TOWN AND COUNTRY PLANNING ACT 1990 FULL

Reference: H16-0030-17 **Date of Decision:** 7th September 2018
Applicant: Ms S Street
Akita Place
Clay Lake
Spalding
Lincs
PE12 6BL
Location: Akita Place Clay Lake Spalding
Description: Siting of mobile home (retrospective).

Drg No 2704 / 02

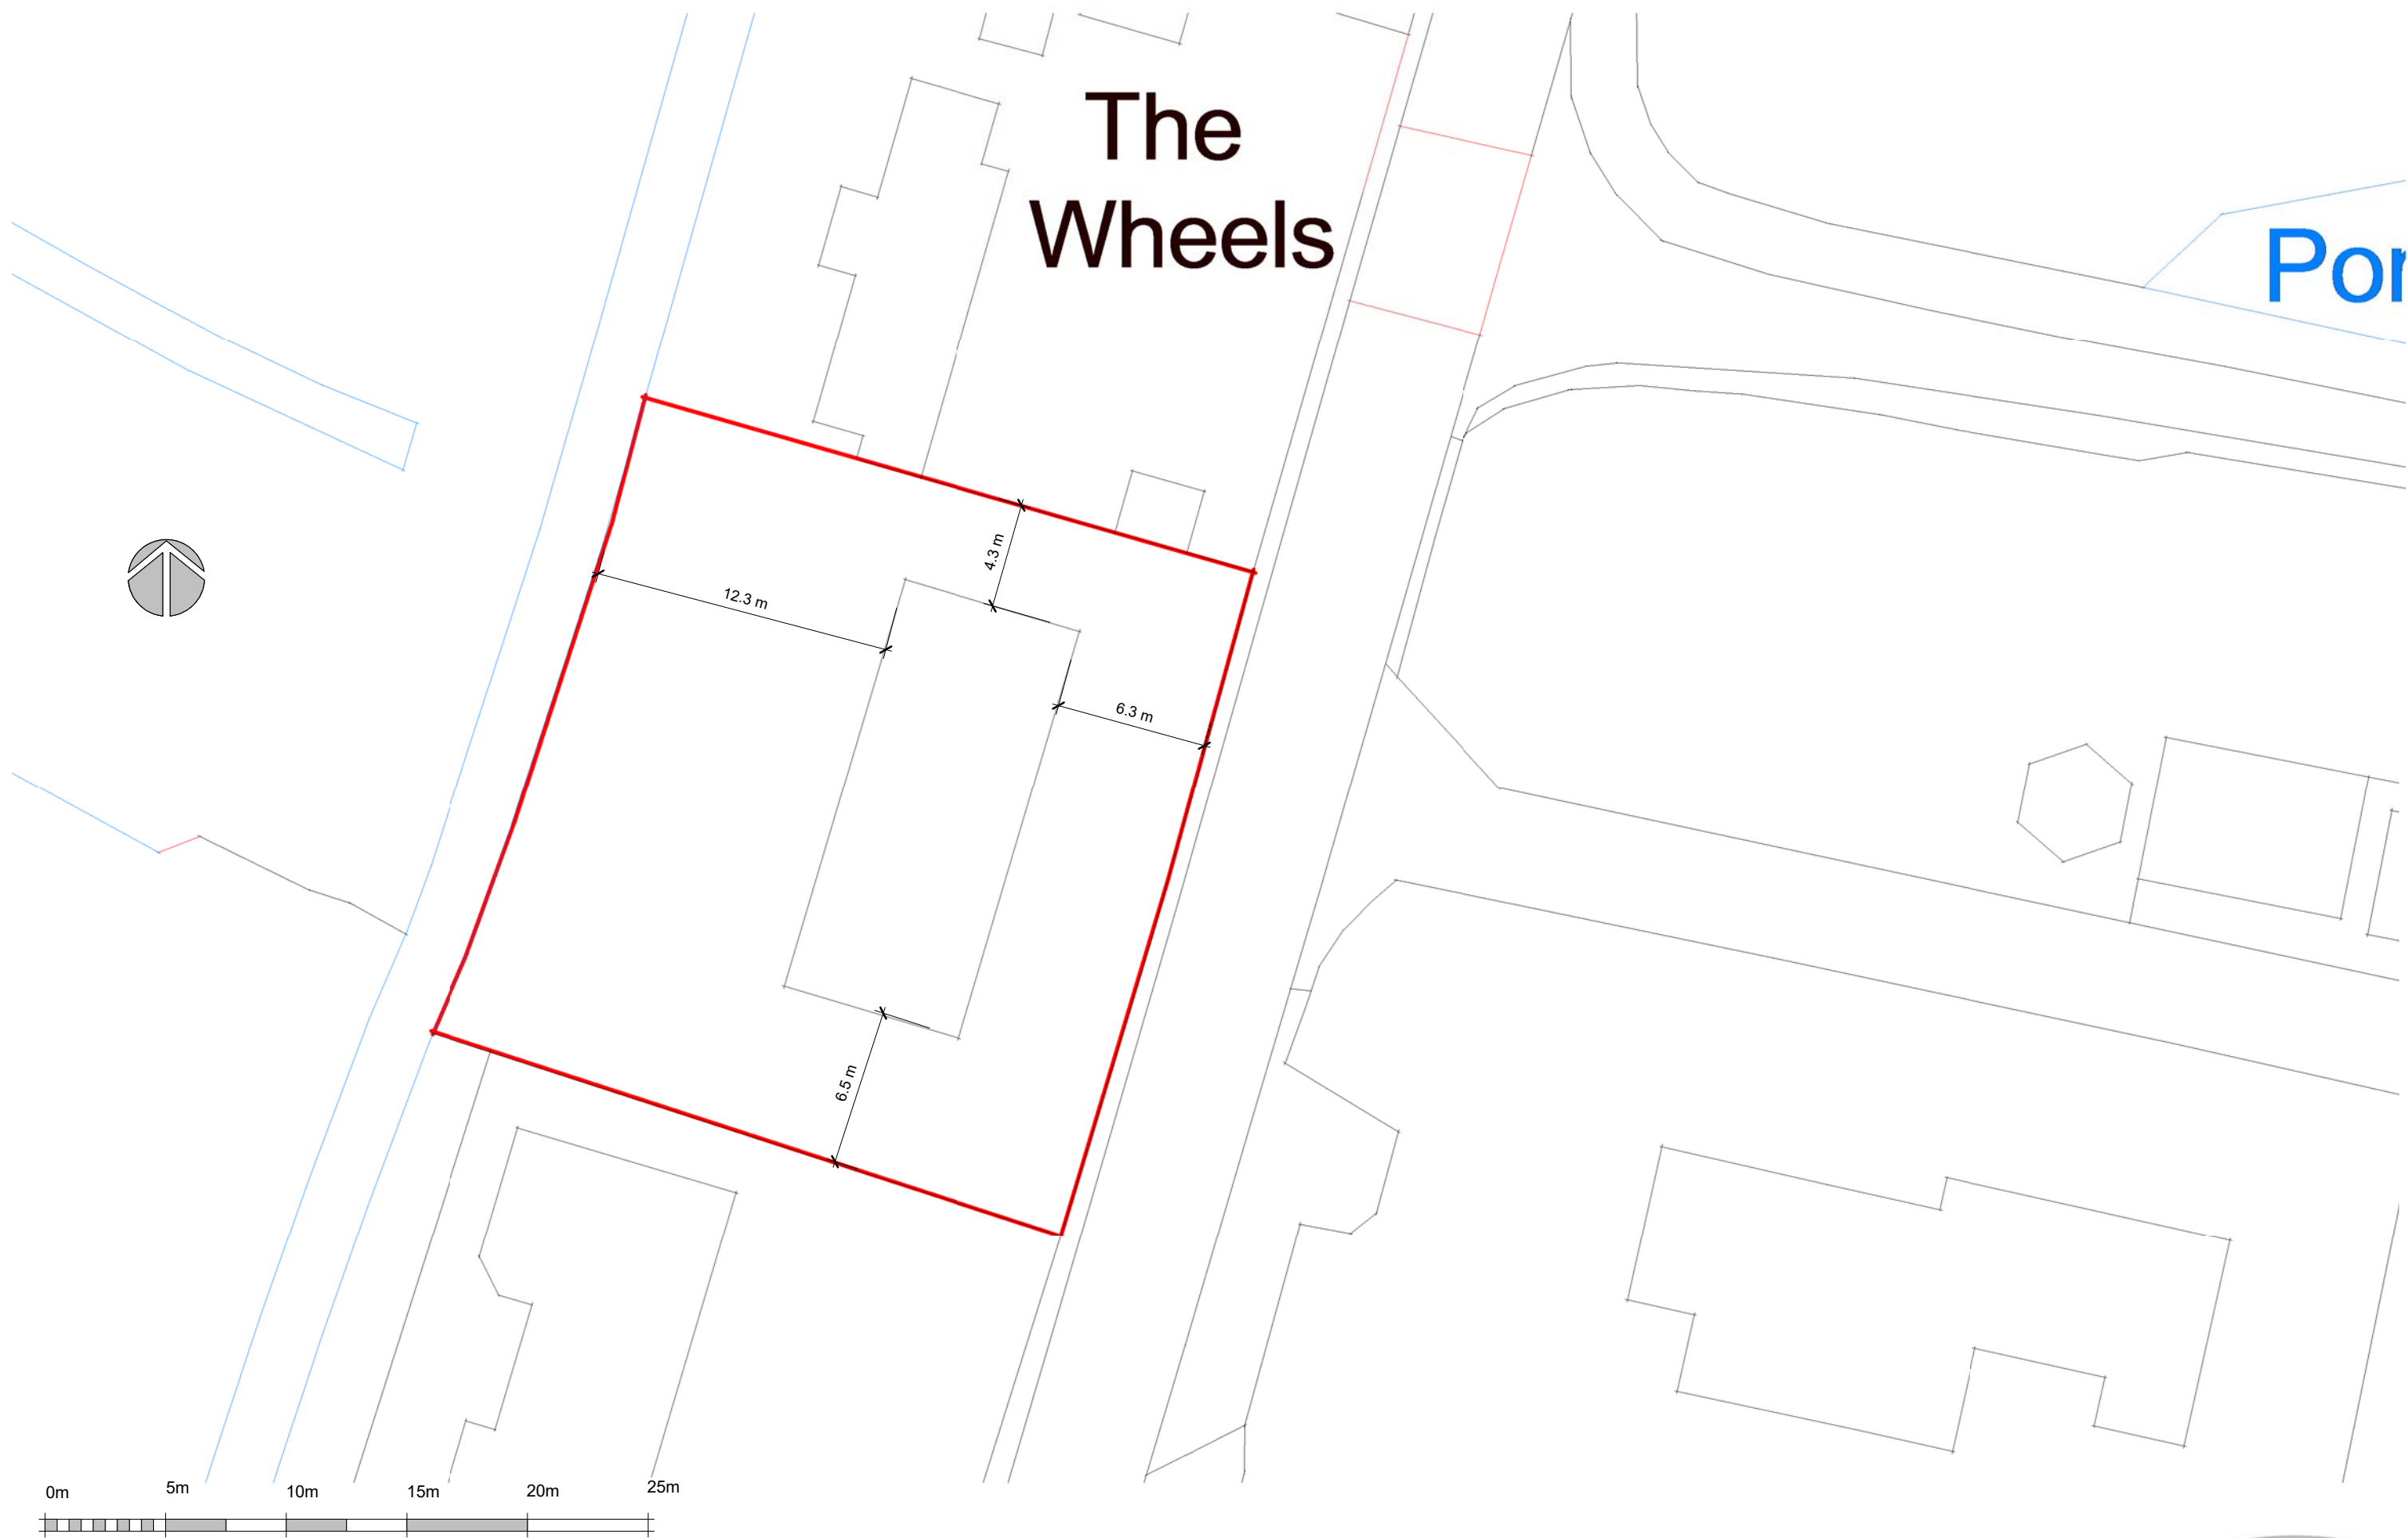
- 3 As a result of the height and layout of the mobile home, it is considered that the development gives rise to an unacceptable level of overlooking, and the perception of overlooking, to the neighbouring properties of Tomar Lodge, The Wheels, and to Milestone Cottage to the east, contrary to Policy SG17 of the South Holland Local Plan, 2006. This policy is in accordance with advice within the NPPF 2018. Paragraph 130 states that permission should be refused for development of poor design that fails to take the opportunities available for improving the character and quality of an area and the way it functions. Paragraph 122 stipulates that development make efficient use of land taking in to account, inter alia, the desire of maintaining an area's prevailing character and setting, and the importance of securing well designed and healthy places.
